V1_ Construction Drawing Set.pdf Markup Summary

Planner (6)

Subject: Planner
Page Label: [4] 302460-14885770_G0-CD.dwg-C-201
Author: MirandaBenson2
Date: 1/14/2025 2:32:09 PM
Status:
Color: ■
Layer:
Space:

SHEET NUMBER: C-101	REVISION: 0
-------------------------------	-----------------------

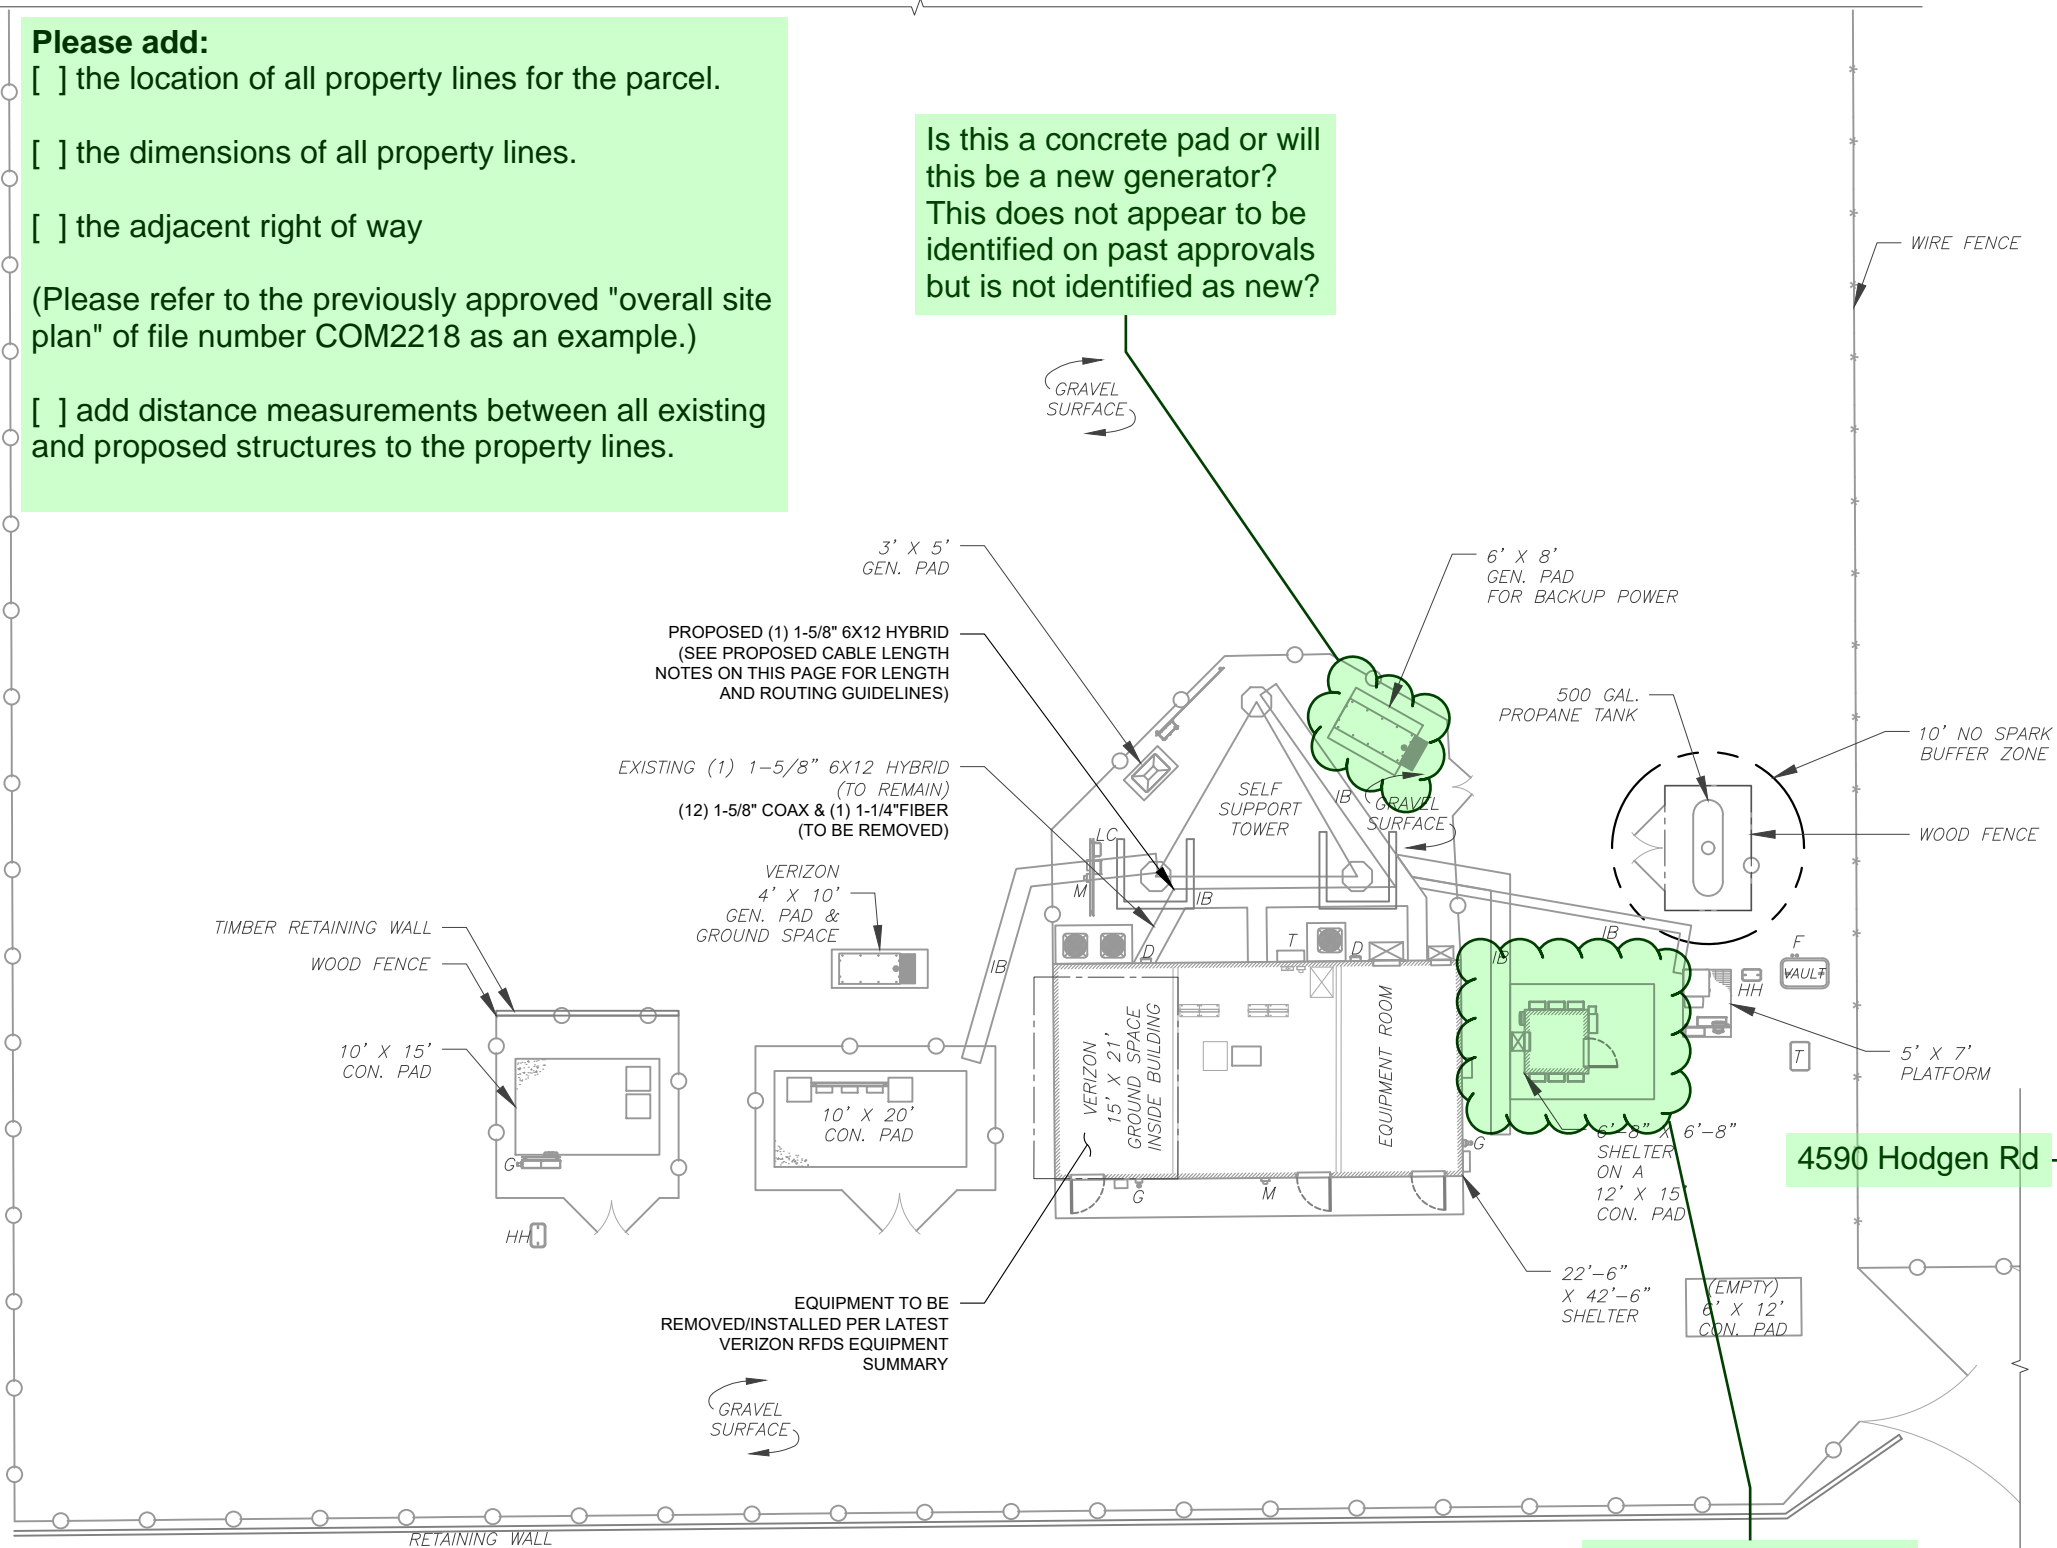
Please add:
[] the location of all property lines for the parcel.
[] the dimensions of all property lines.
[] the adjacent right of way

(Please refer to the previously approved "overall site plan" of file number COM2218 as an example.)

[] add distance measurements between all existing and proposed structures to the property lines.

Is this a concrete pad or will this be a new generator? This does not appear to be identified on past approvals but is not identified as new?

Does this need to be added to the proposal? This does not appear to be identified on past approvals.

SHEET NUMBER: C-201
REVISION: 0

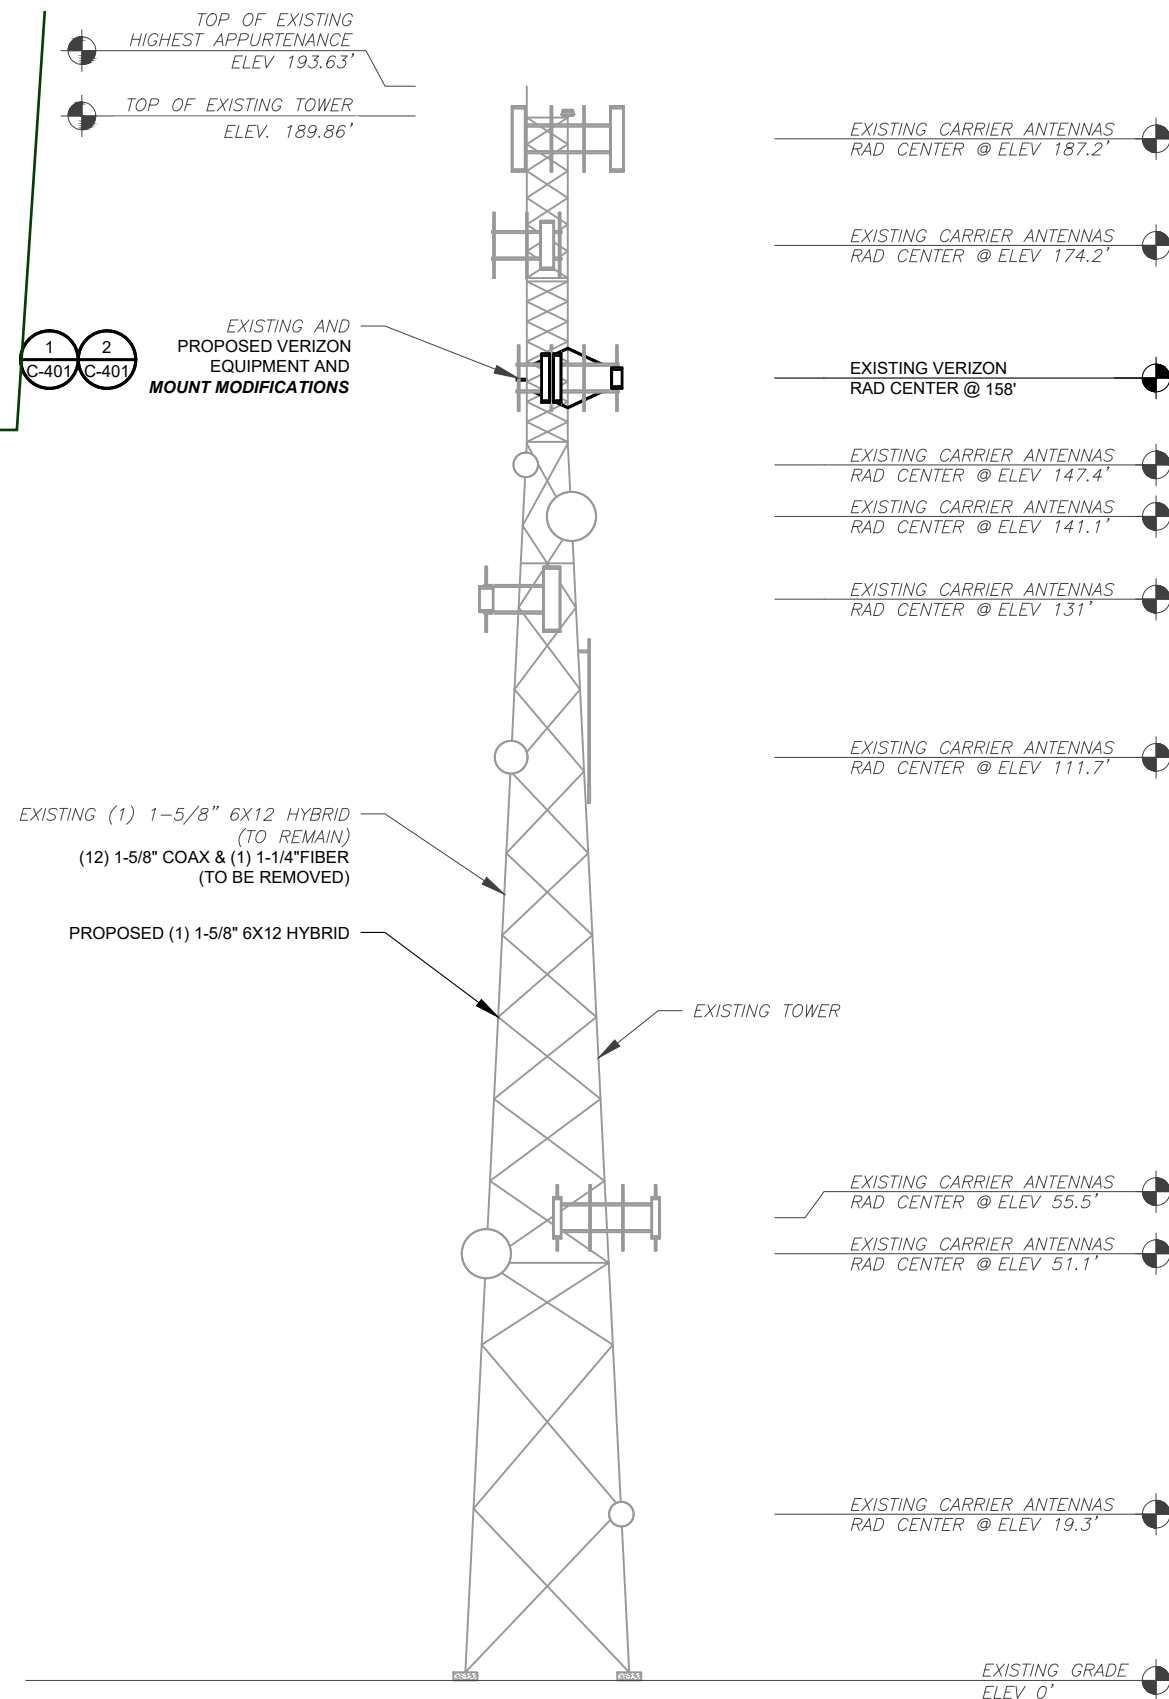
Variance of Use approval (VA211) and all previous PPR- / COM- / TWR- approvals have identified a 170' height limit to this tower. Most recent file numbers include PPR2127 and COM2218. I do not see approval for an increase to this limit with our department.

If you are proposing to exceed the approved height limit, a new Variance of Use may be required per LDC Section 5.2.19(B)(6)(e)(i) -

"A modification constitutes a Substantial Change if:(i)It increases the height of the tower by more than 10% or by the height of one additional antenna array with separation from the nearest existing antenna not to exceed twenty feet, whichever is greater; for other eligible support structures, it increases the height of the structure by more than 10% or more than ten feet, whichever is greater. Changes in height should be measured from the original support structure in cases where deployments are or will be separated horizontally, such as on buildings' rooftops; in other circumstances, changes in height should be measured from the dimensions of the tower or base station, inclusive of originally approved appurtenances and any modifications that were approved prior to the passage of the Spectrum Act;"
